Response to Planning application from Hertfordshire County Council (T and CP GDP Order 2015)

District ref: 6/2023/0241/COND
HCC ref: WH/15711/2023
HCC received: 13 February 2023
Area manager: Matthew Armstrong
Case officer: Matthew Armstrong

Land to the north east of King George V Playing Fields Northaw Road East Cuffley EN6 4RD

Submission of details pursuant to condition number 4 (Construction Environment Management Plan (CEMP), on planning permission S6/2015/1342/PP

Fig. 6.2 Proposed routing between site and M25 Junction 24 (Potters Bar)

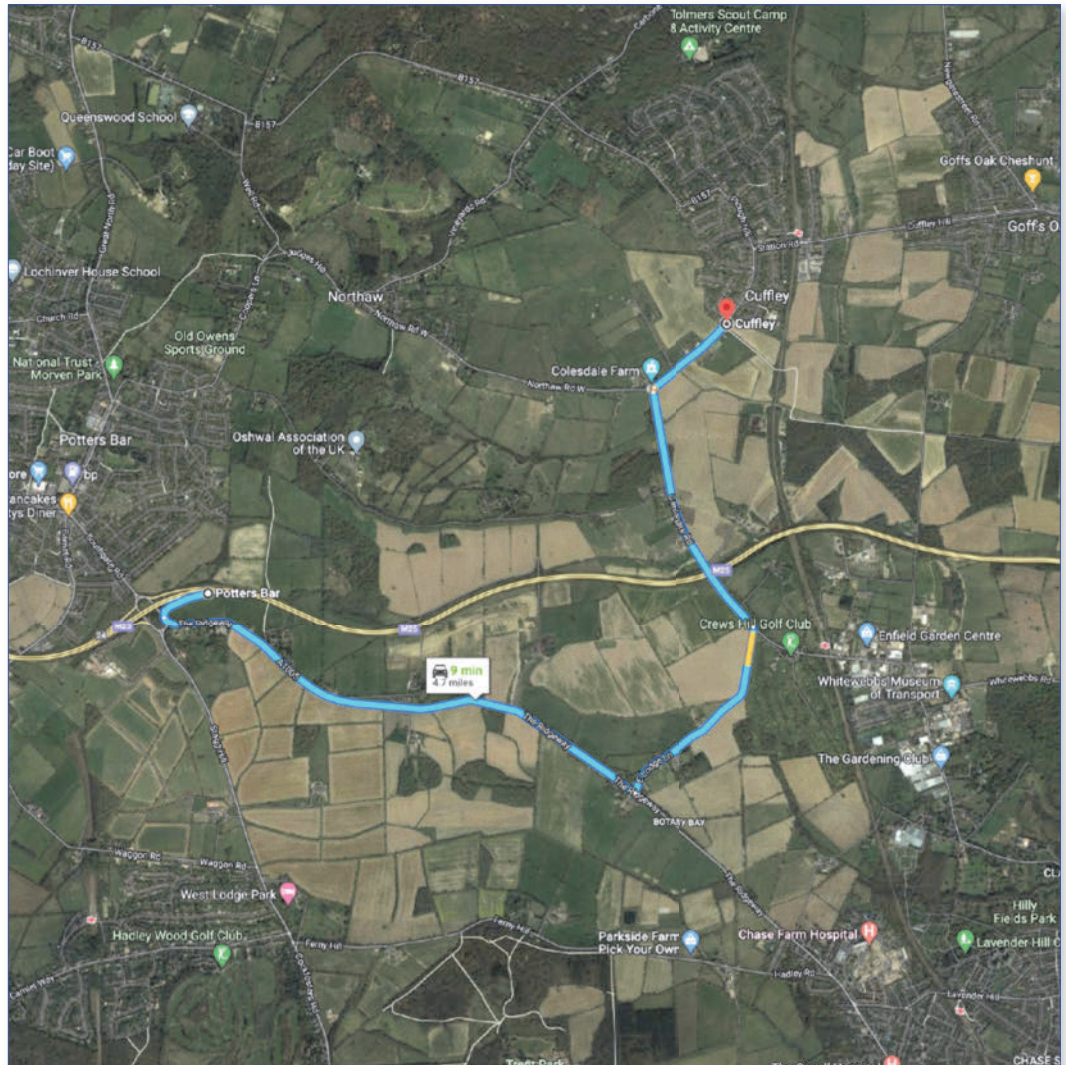
Section 6.1.2 states that all construction traffic "except for very local traffic" will approach the site from the M25. It is not clear how "very local traffic" is defined.

Much of the proposed construction traffic route is outside of Hertfordshire, within the boundary of the London Borough of Enfield. Therefore, the LPA should consult the London Borough of Enfield on this CTMP for their views too.

Fig. 6.4 Temporary site access image mark up

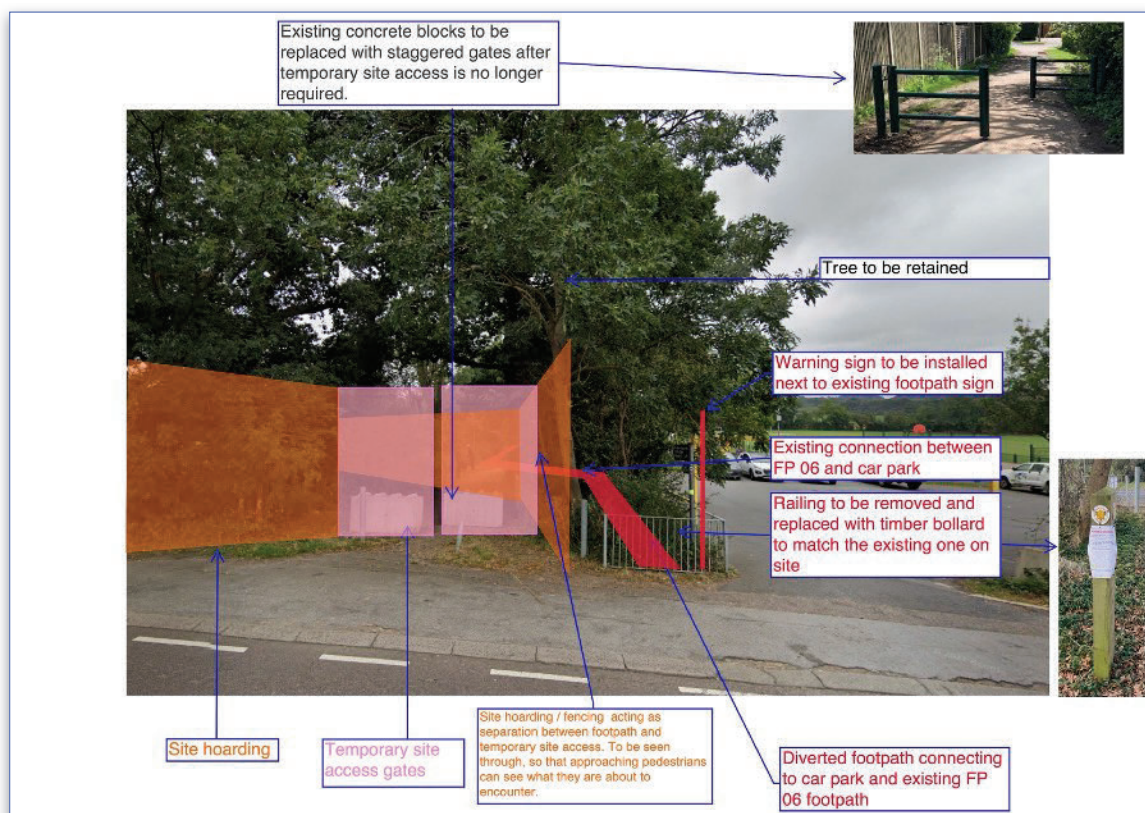
However, the applicant proposes the use of a temporary access point to the site which is also a well used public right of way (Northaw Footpath 6). This raises significant concerns. There are no details in the CTMP as to how users of this right of way will be protected from construction vehicle movements. There are no details of the level of visibility from this access point onto B156 / Northaw Road East, or its design / width / etc. there are no tracking plans for construction vehicles in and out this temporary access point, and into / out of the site onto the right of way. This setup is highly questionable, especially bearing in mind the playing field access immediately adjacent, and the confusion that signalling / turning vehicles might cause to other road users (i.e. it will not be clear which access they are turning into)
